## Application 2018/93591 as amended with new design of building

We strongly object to the proposed application being approved.

Drawing
Proposed Site Plan

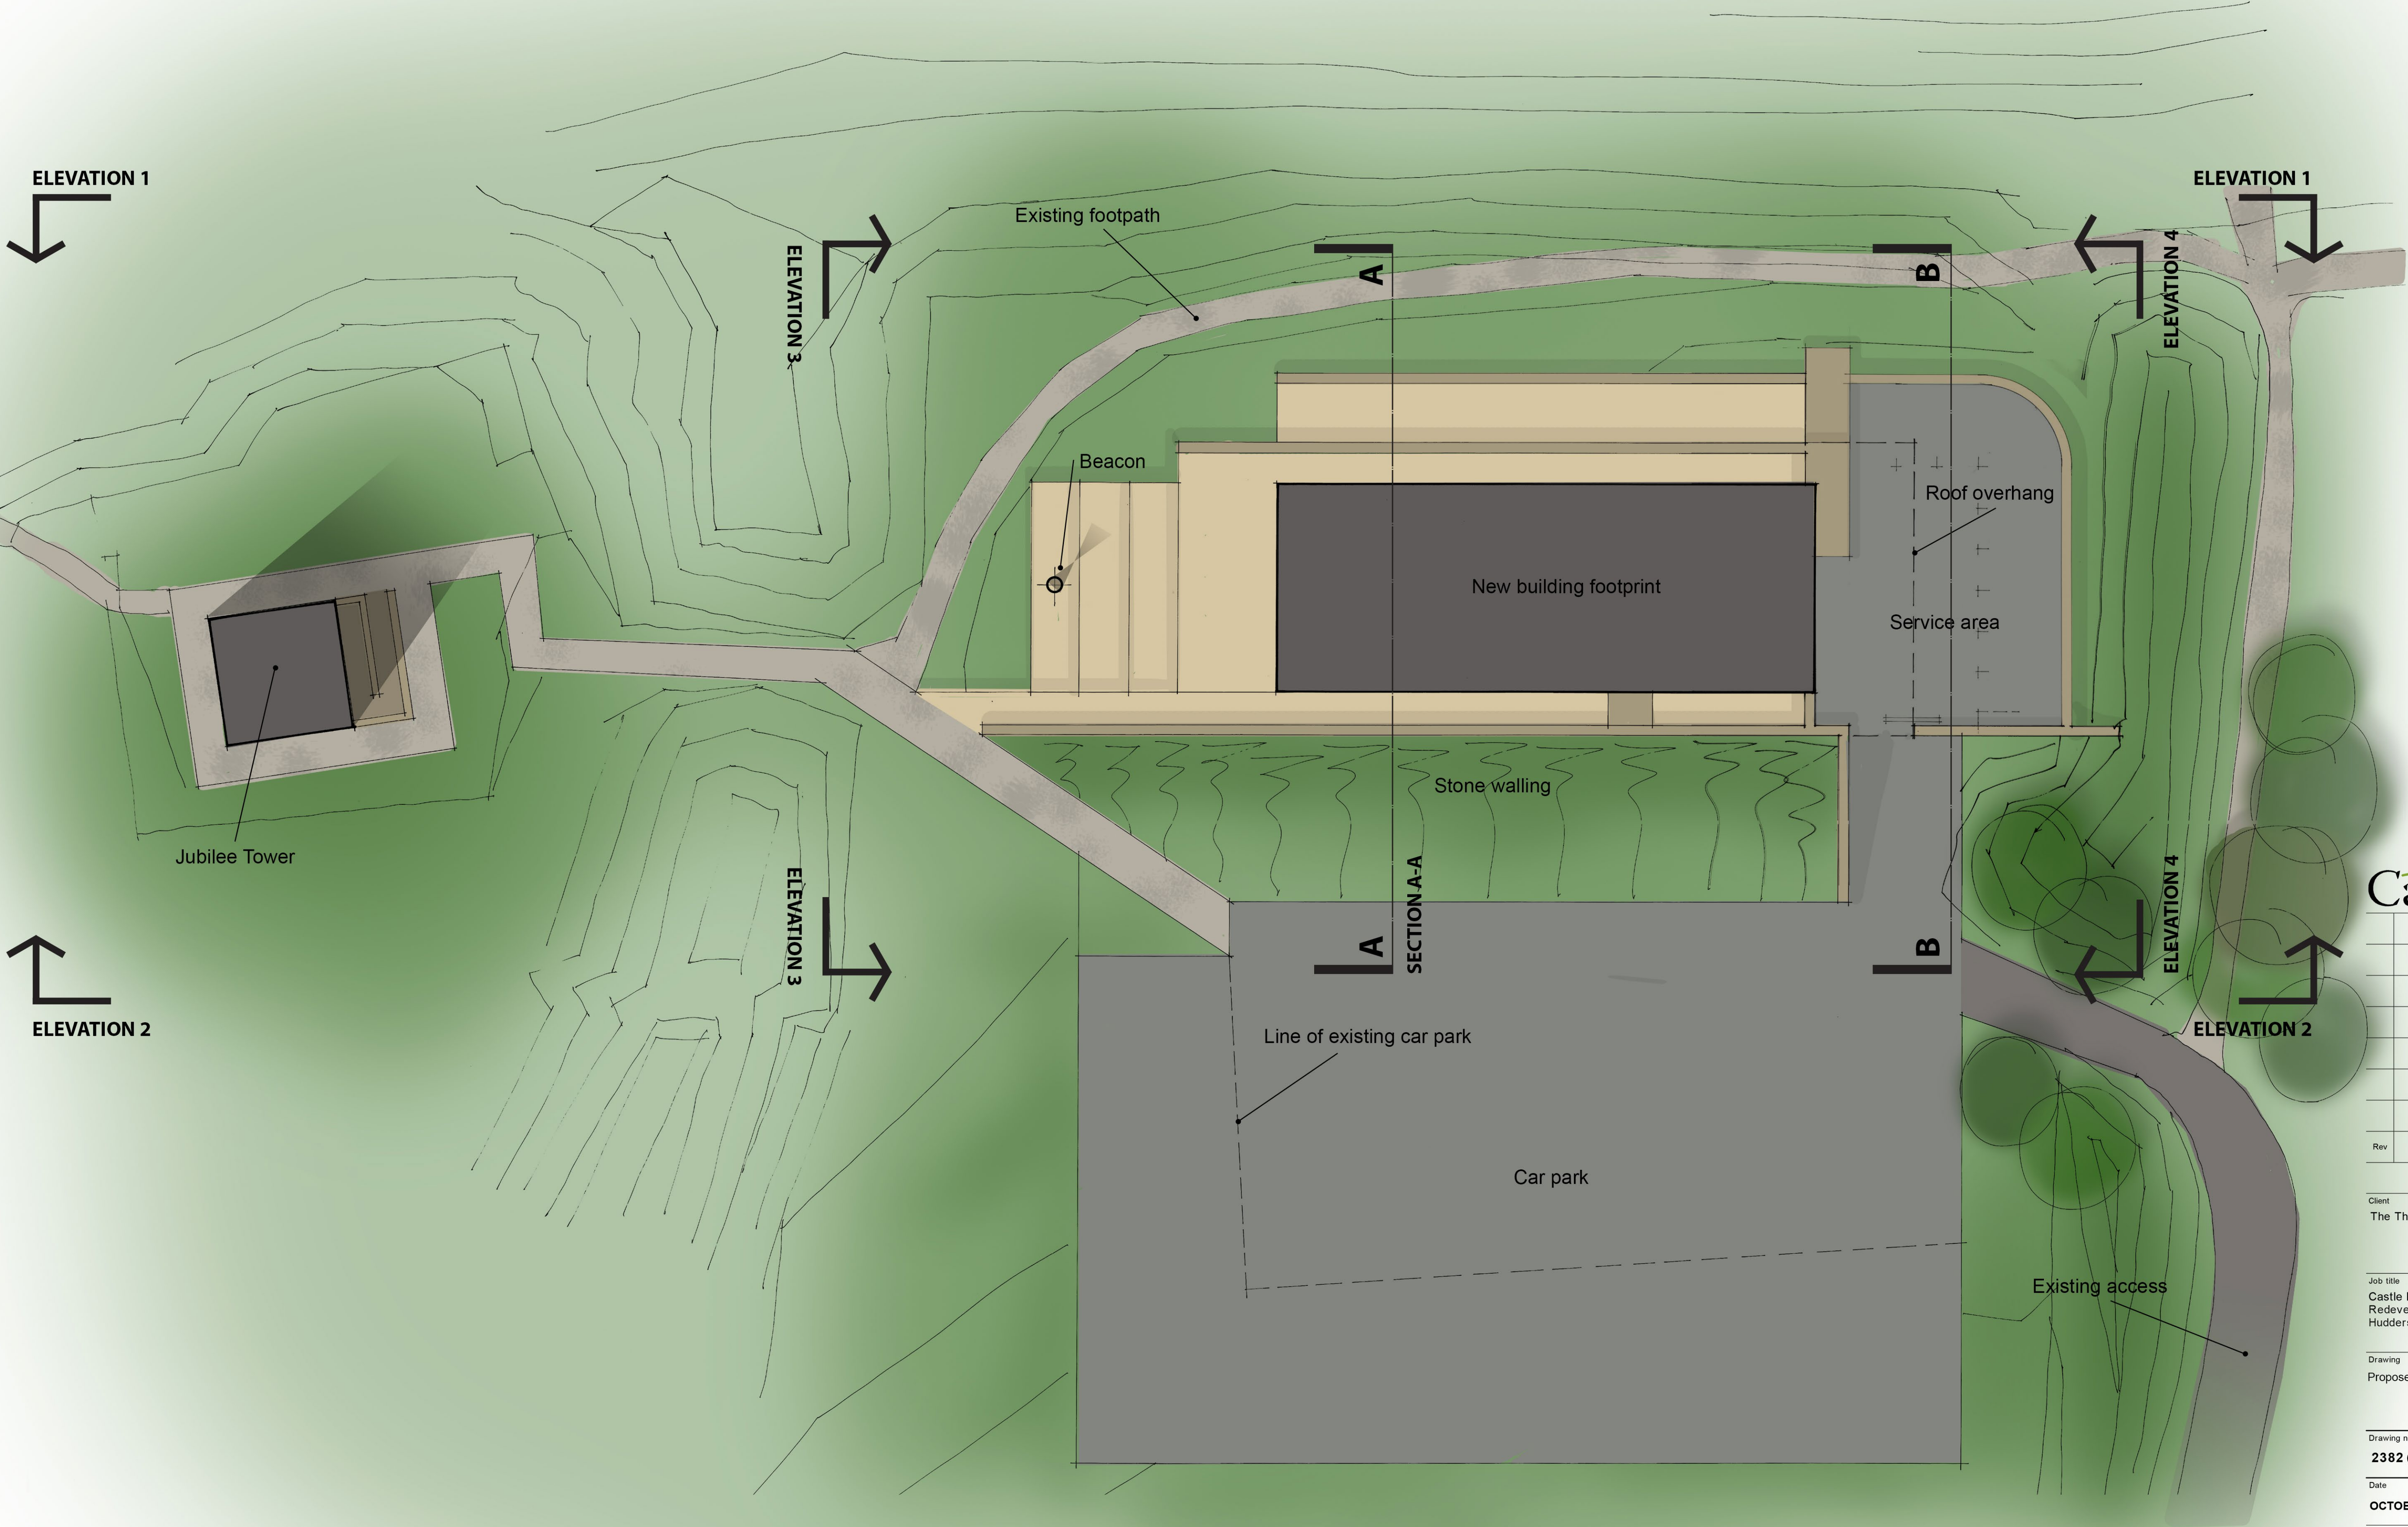
The new building still takes up a substantial footprint of the scheduled monument site, which would not allow for any further archaeological investigations or creating a sympathetic heritage site in the future if the community wished to do so (obviously with planning considerations). This site is an important national heritage site that needs to be preserved for generations to come.

We note that the footprint is still substantially larger than the old hostelry and that given the number of restaurant covers and space allocated for vehicles, the top of Castle Hill may well be considered the domain of the restaurant and venue owners. This is unacceptable. We have been up on Castle Hill on many occasions recently where, without the building, the car park is already fully occupied and the open aspect of the site is being utilised by the community and visitors (see image – taken on what would be the footprint of the building. This day had a full car park). The image shown is a day when the tower was open, and the car park was full.

There has been no effort on the part of the lease holder to demonstrate how the ingress and egress will be managed, other than to widen the road with passing places. This has the potential to create more issues than it solves and the widening would not be sufficient (as shown on the drawings) to handle two large vehicles on the road, especially as some of those would be delivery and refuse vehicles.

Proposed Basement Floor Plan 1:100

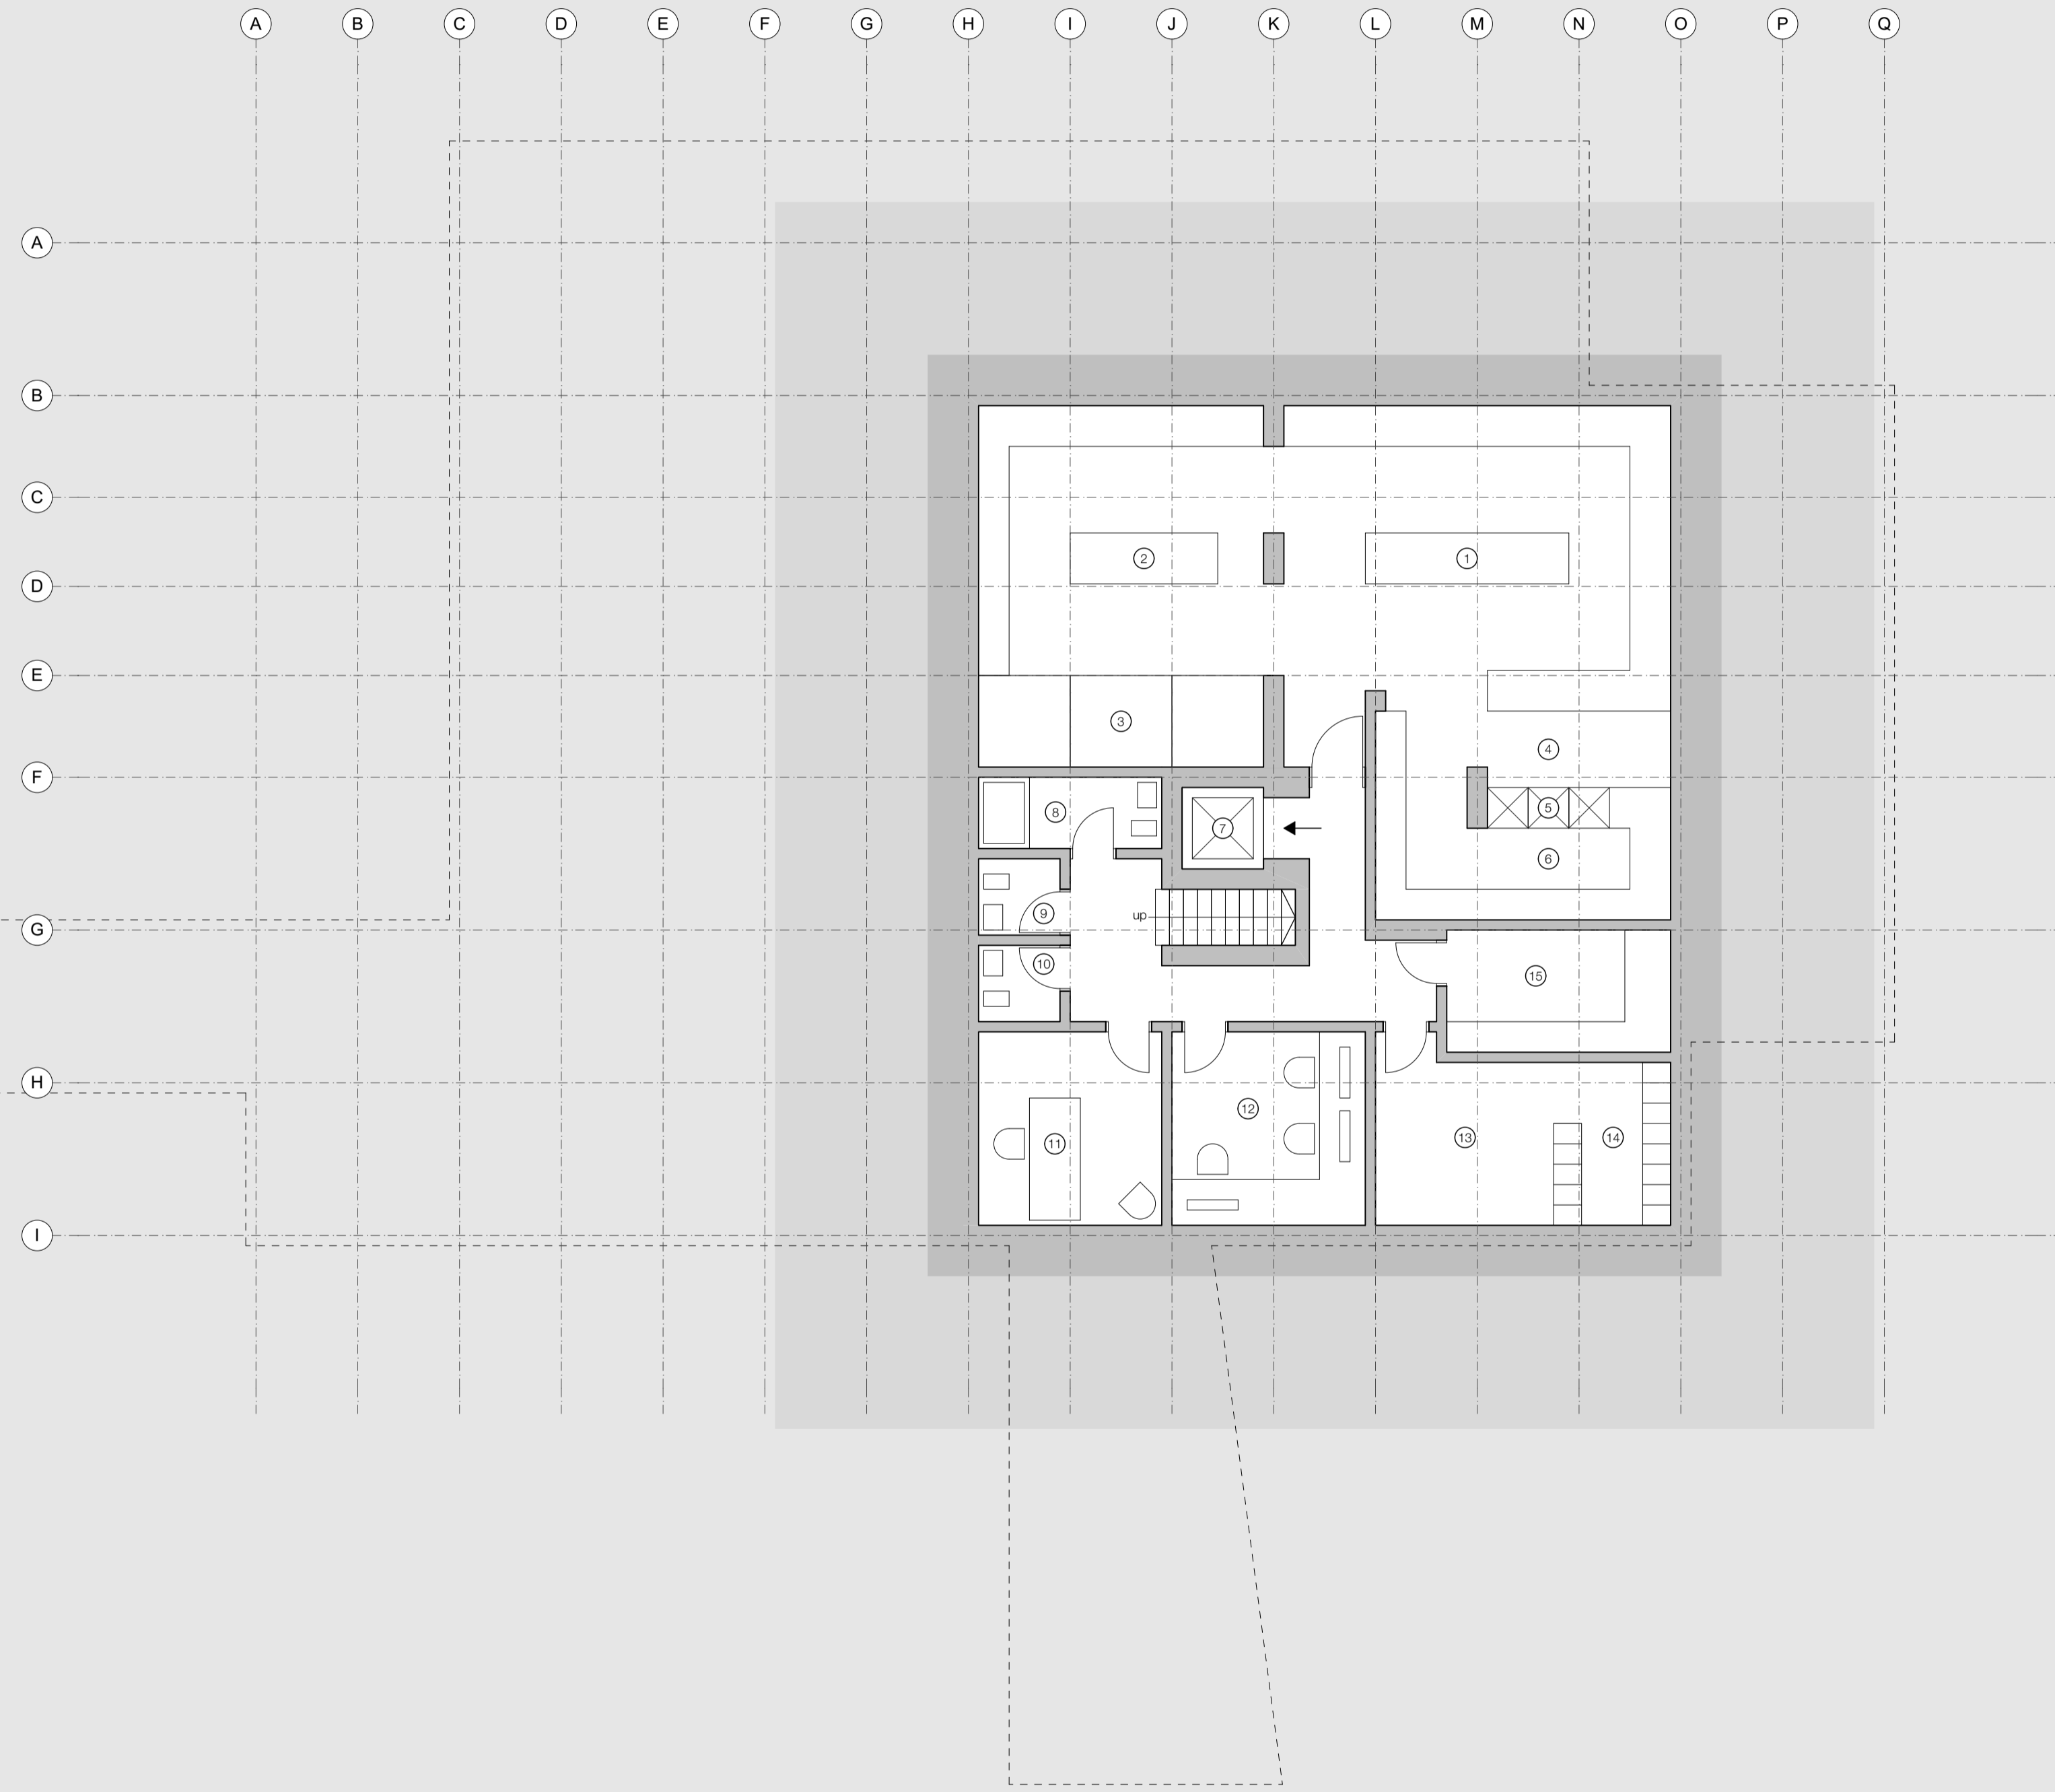
The proposed building will dominate the site, it will also be subterranean in part, which is to a depth far beyond that which has been surveyed for these applications. We are concerned that this may have a physical impact on the historic site.

Job Title Castle Hill, Huddersfield	
Client The Thandi Partnership	
Status Planning	Company AD
Drawing Proposed Elevations Sheet 2 of 1:200 2	
Date October 2019	Drawn / Checked FWG
Drawing No. 3267 (0-) 09	Revision -

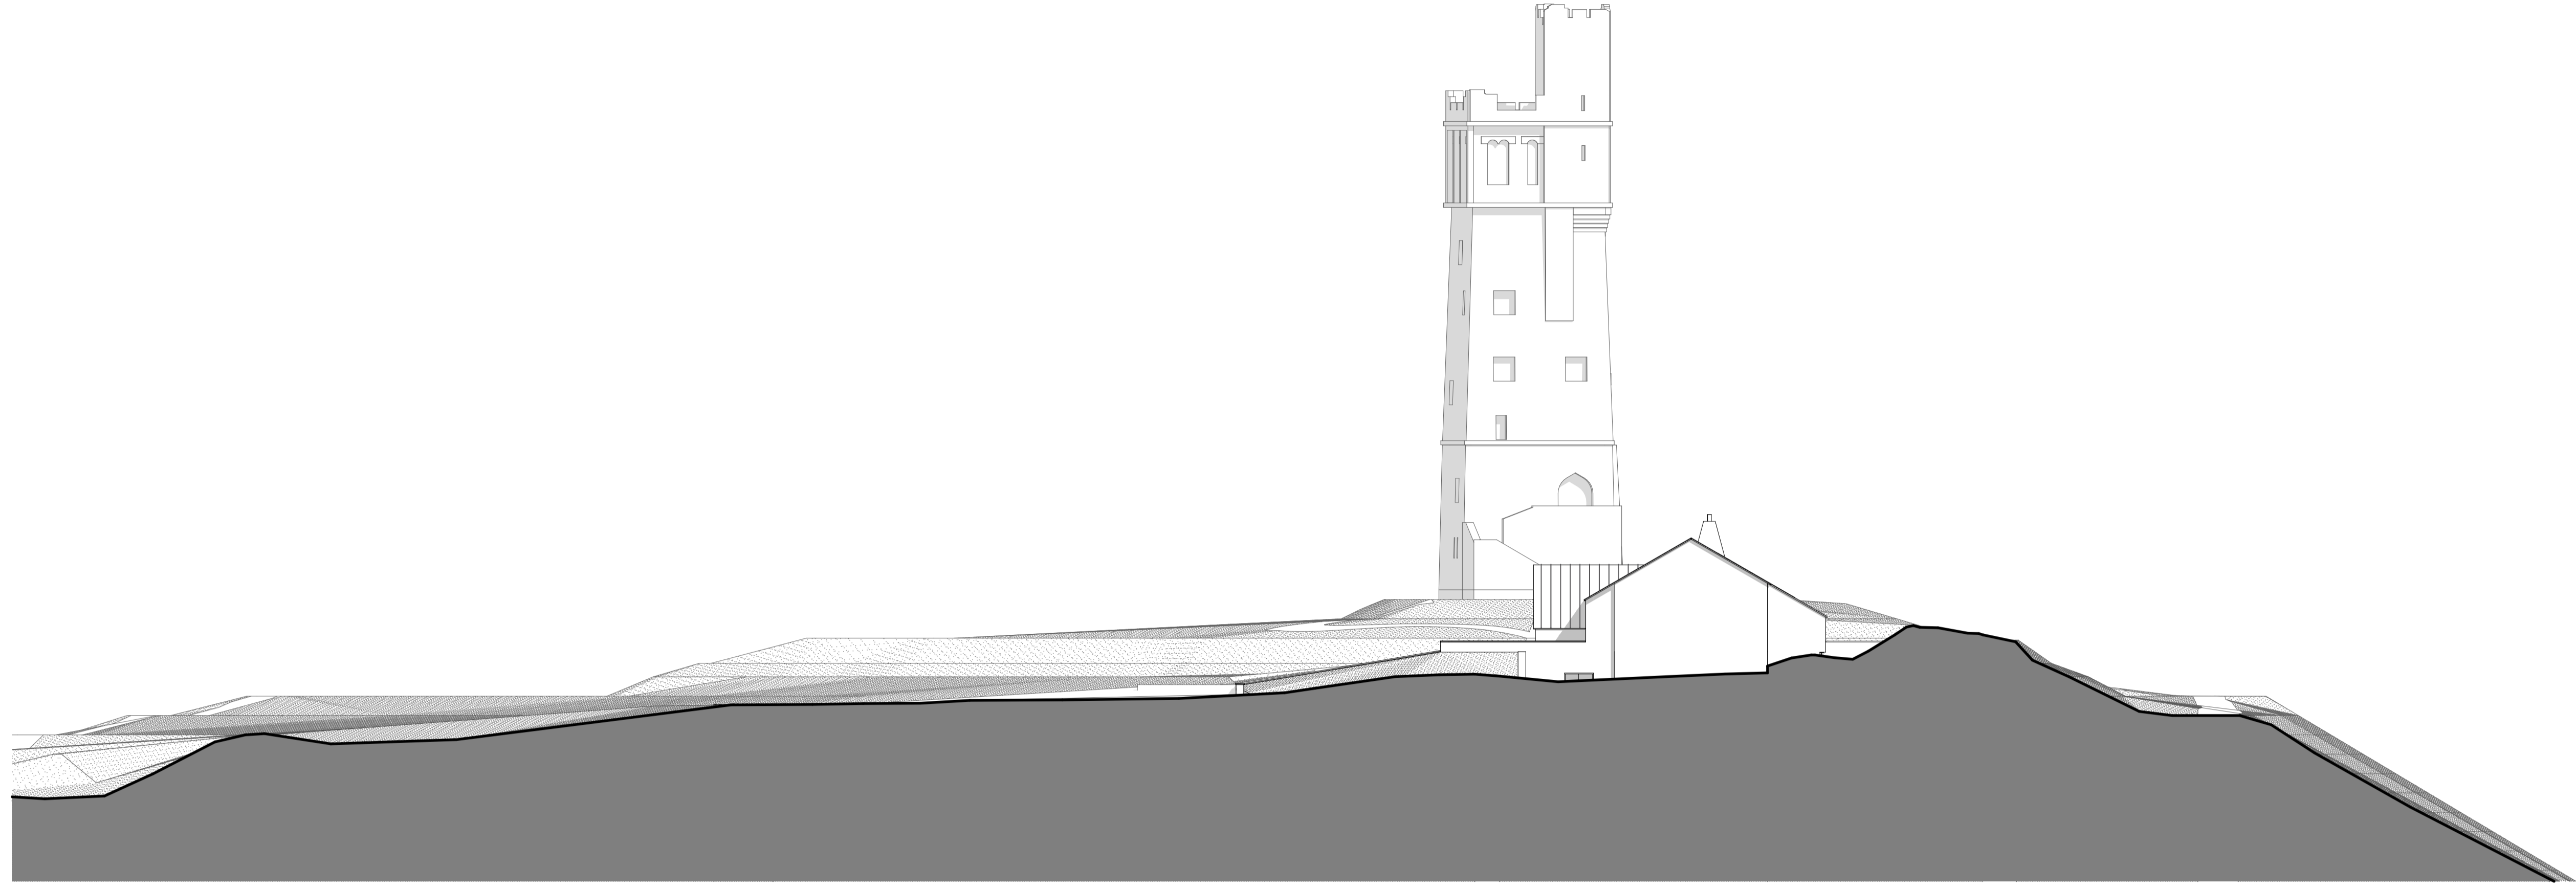
The veranda would bring this noise pollution back on to Castle Hill after a long period without the impact. This is not progress and does not fit with the requirements of the NPPF or Greenbelt.

Even with the new proposed design, the visual impact on the landscape would be considerable. The figure 2 are images from Beaumont park and Hall Bower. Both illustrate what the current views are. It is clear just from these images that the visual
